Application for a non-material amendment following a grant of planning permission.

| Property name                                                            | Garages Site between 15b & 17-17a |

| 1 x two-storey, 3-bed dwelling with associated parking and amenity space, bin and cycle store, involving demolition of existing garages |                     |
| Reference number:                                                                                                                       | 73080/APP/2018/2707 |

PROPOSED NON-MATERIAL AMENDMENT
GROUND FLOOR PLAN

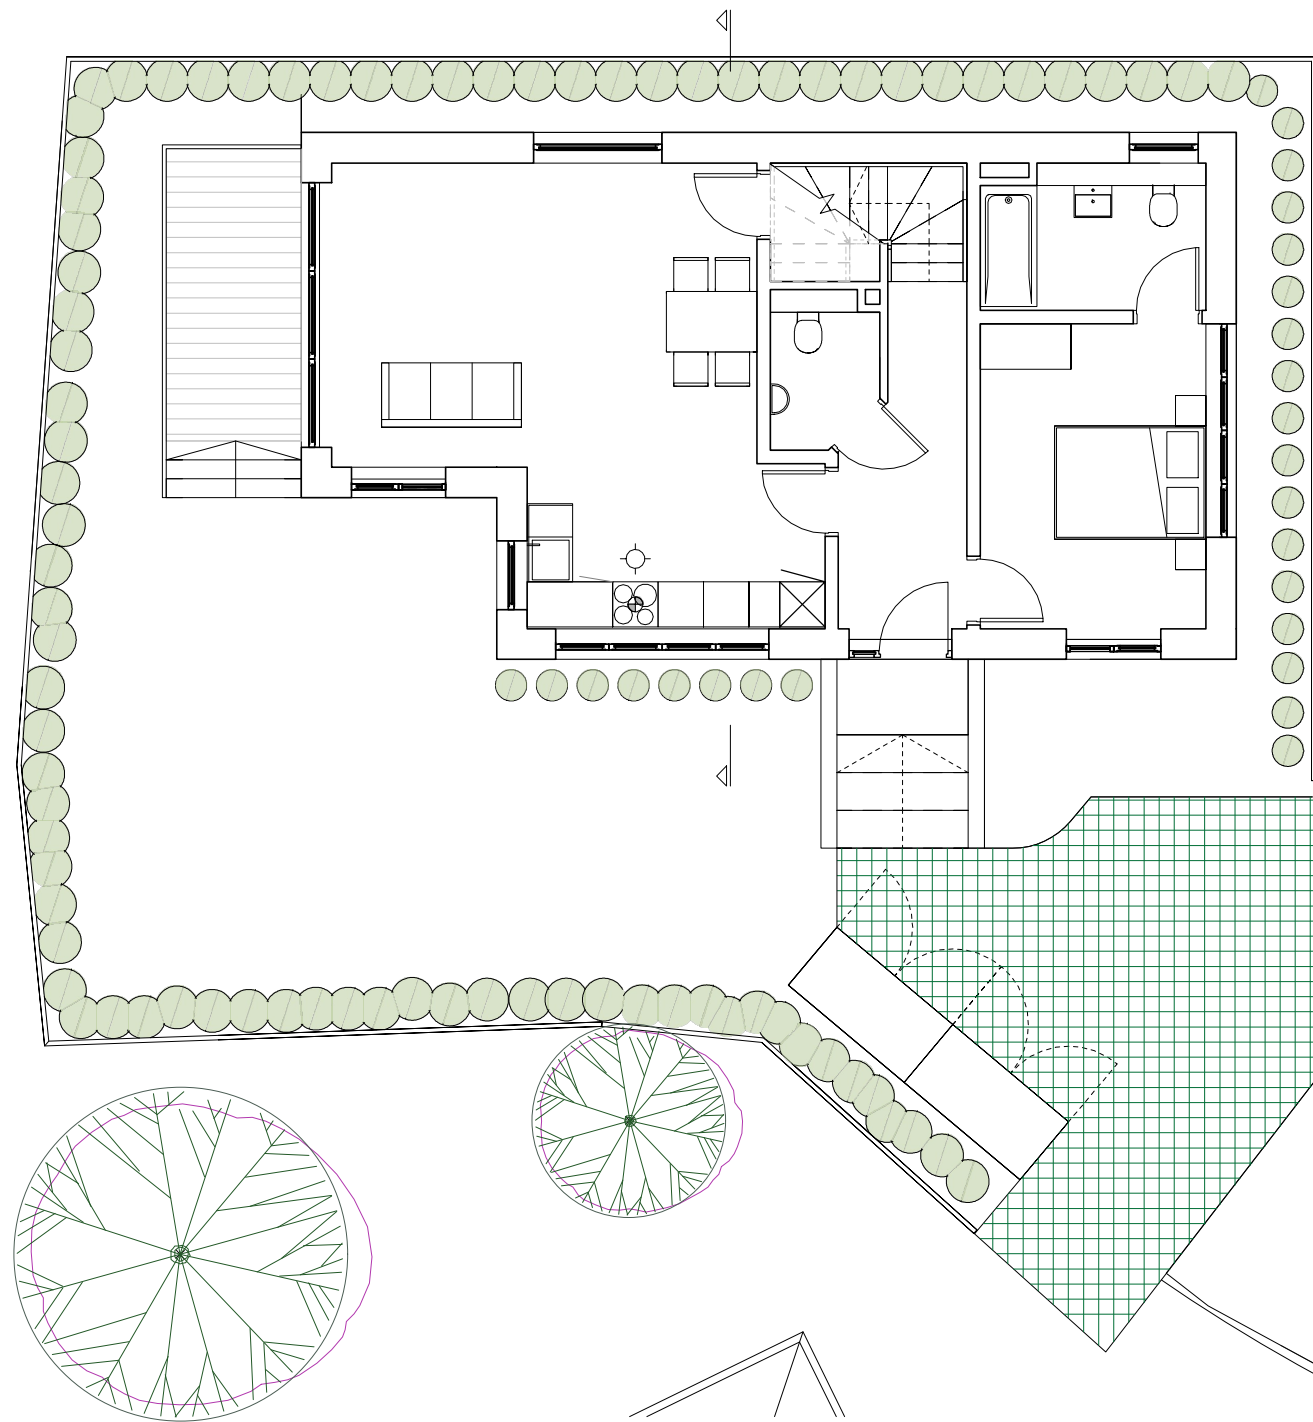
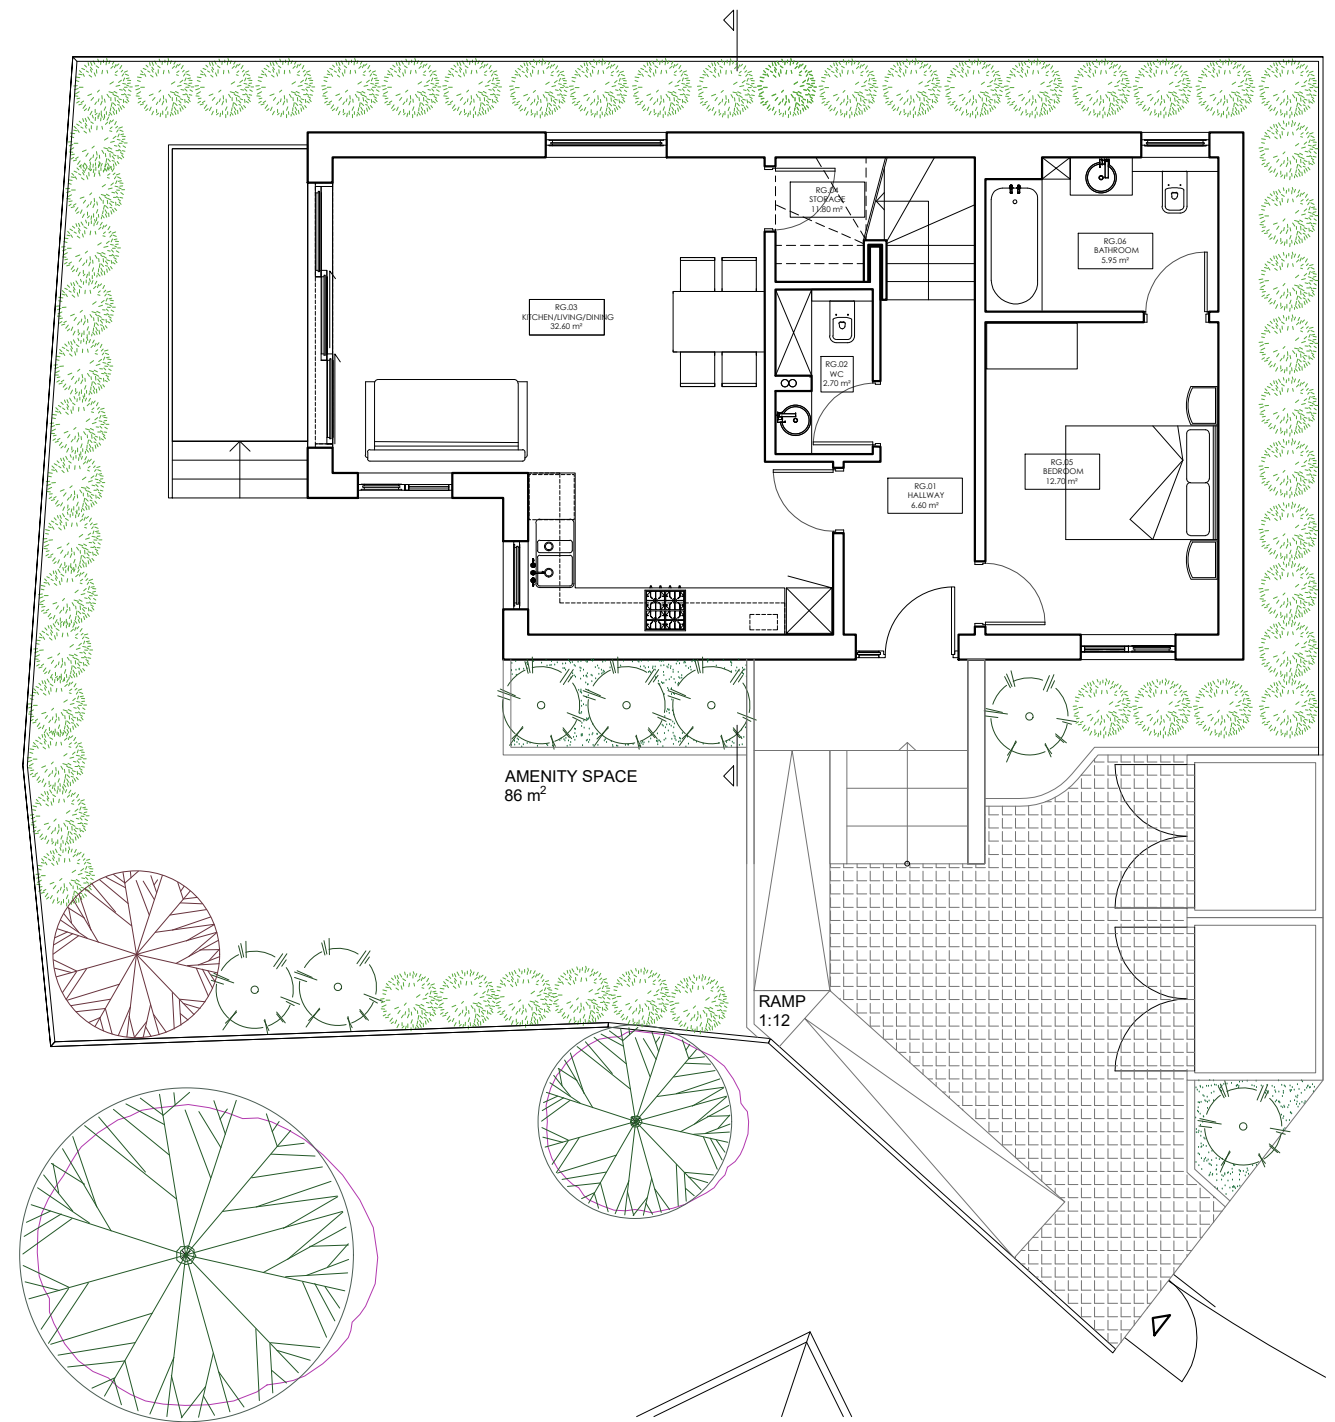
• Addition of a 1:12 ramp with 1 m width in the front of the property in the west side, where the refuse and bicycle storage were previously located, to provide an accessible route to the main entrance of the building.

• Minor changes in the width of the external stairs leading to the main entrance in order to propose the adjacent ramp. The stairs remain big enough to be practical with 1.6 m width.

• Relocation of the refuse storage to the east of the property, where it will still be accessible from the front entrance.

• Relocation of the bicycle storage to the east of the property next to the refuse storage.

• Removal of the 4 windows on the front facade on the ground floor, where the kitchen is located. These windows are too tall and not practical for the use of the kitchen. The kitchen/living/dining area will receive enough light from the rest of the windows.

• Changes in the layout of the common WC on the ground floor to improve its function.

PROPOSED NON-MATERIAL AMENDMENT
ROOF PLAN

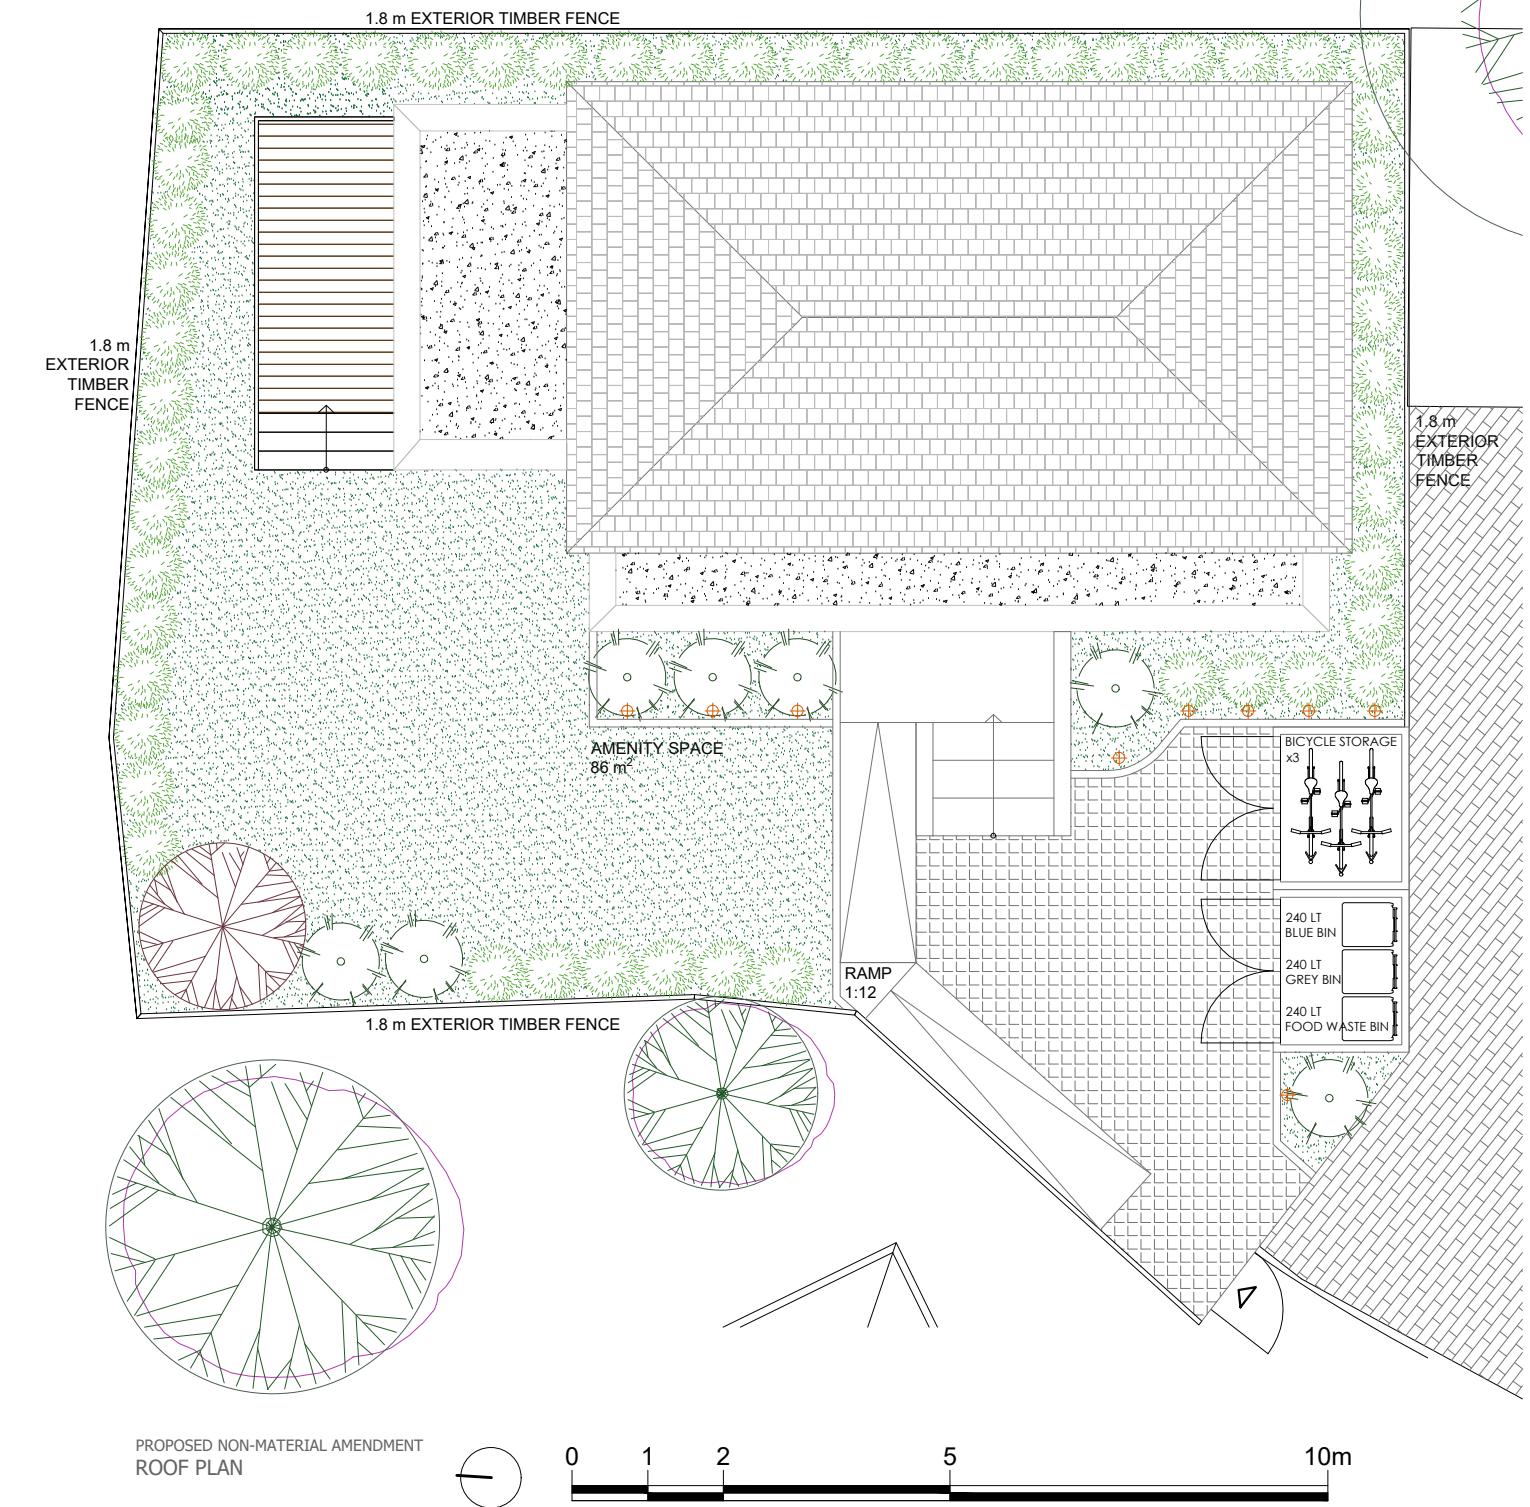
• Removal of the 4 rooflights as there is no proposed loft and there is no need for openings on the roof.

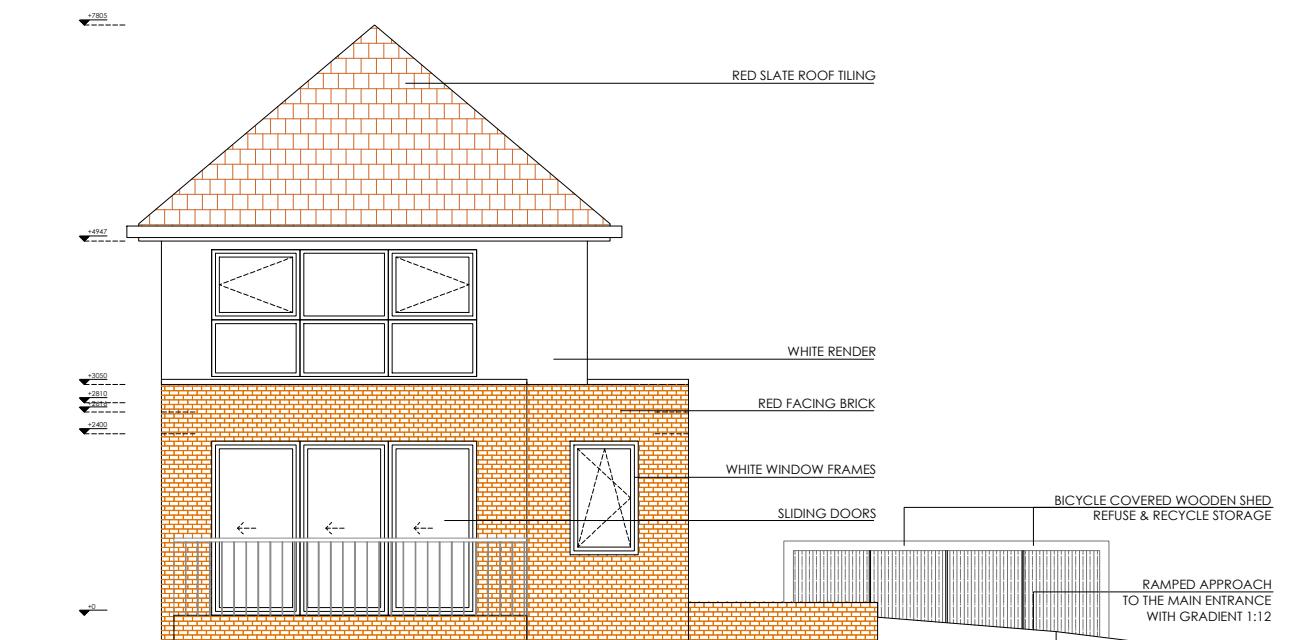
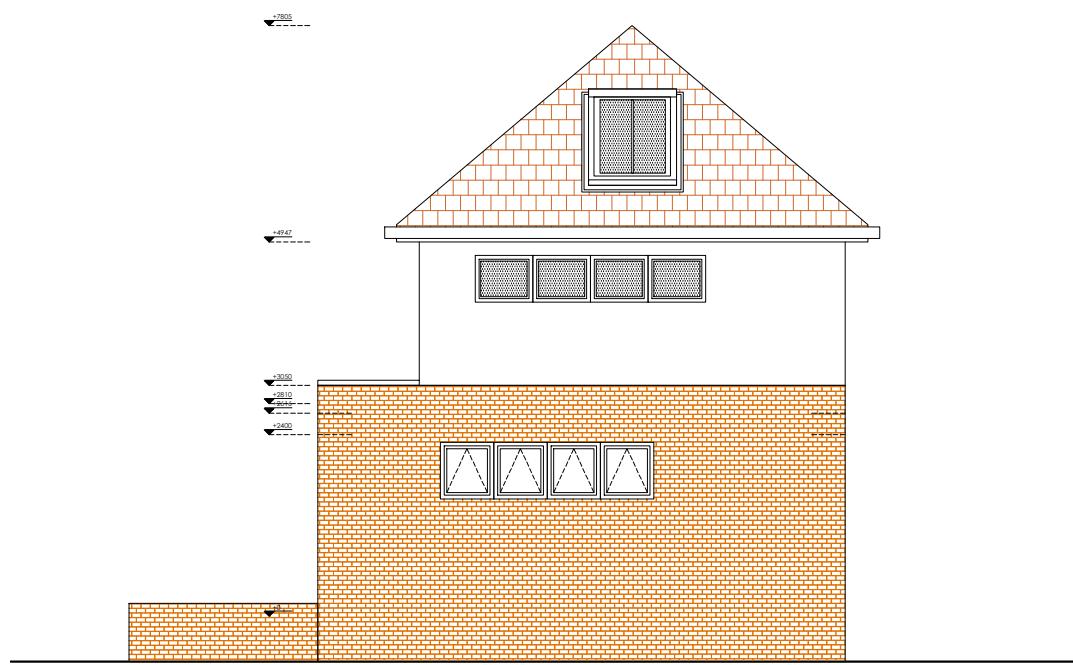
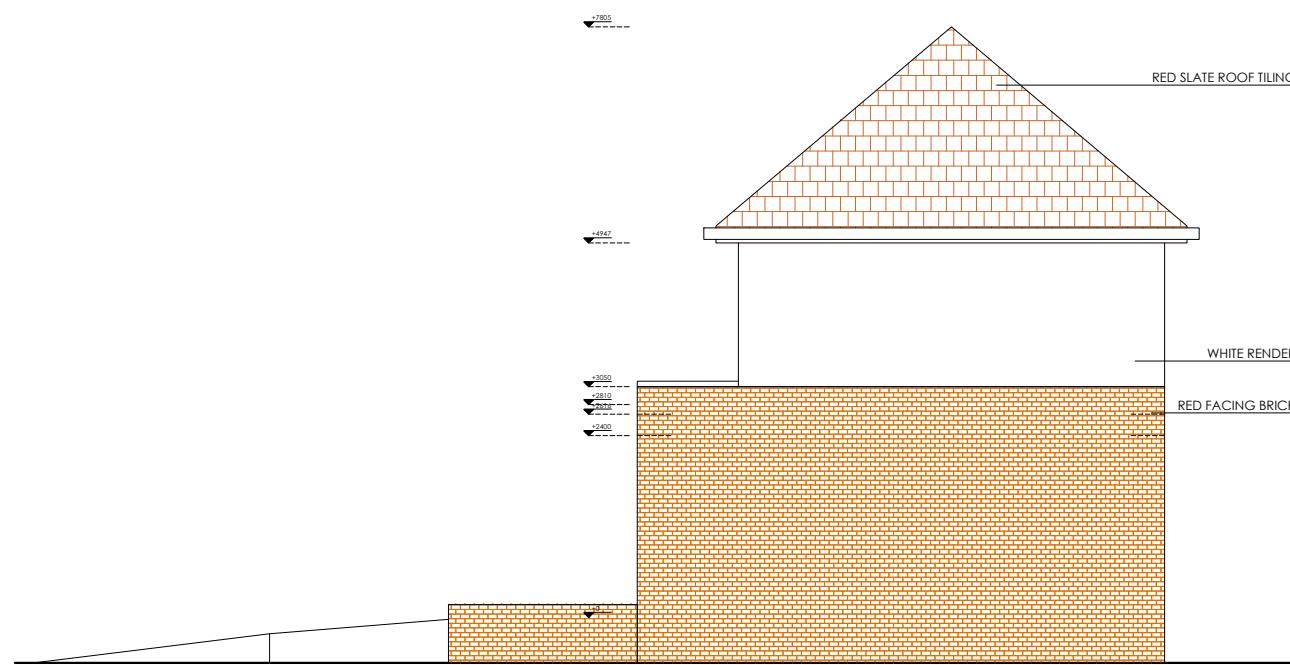
• Removal of the 4 windows on the ground floor and 4 windows on the first floor on the south side elevation. These windows are too tall to be practical. The rooms that they facilitate will receive enough light from the windows on the other sides.
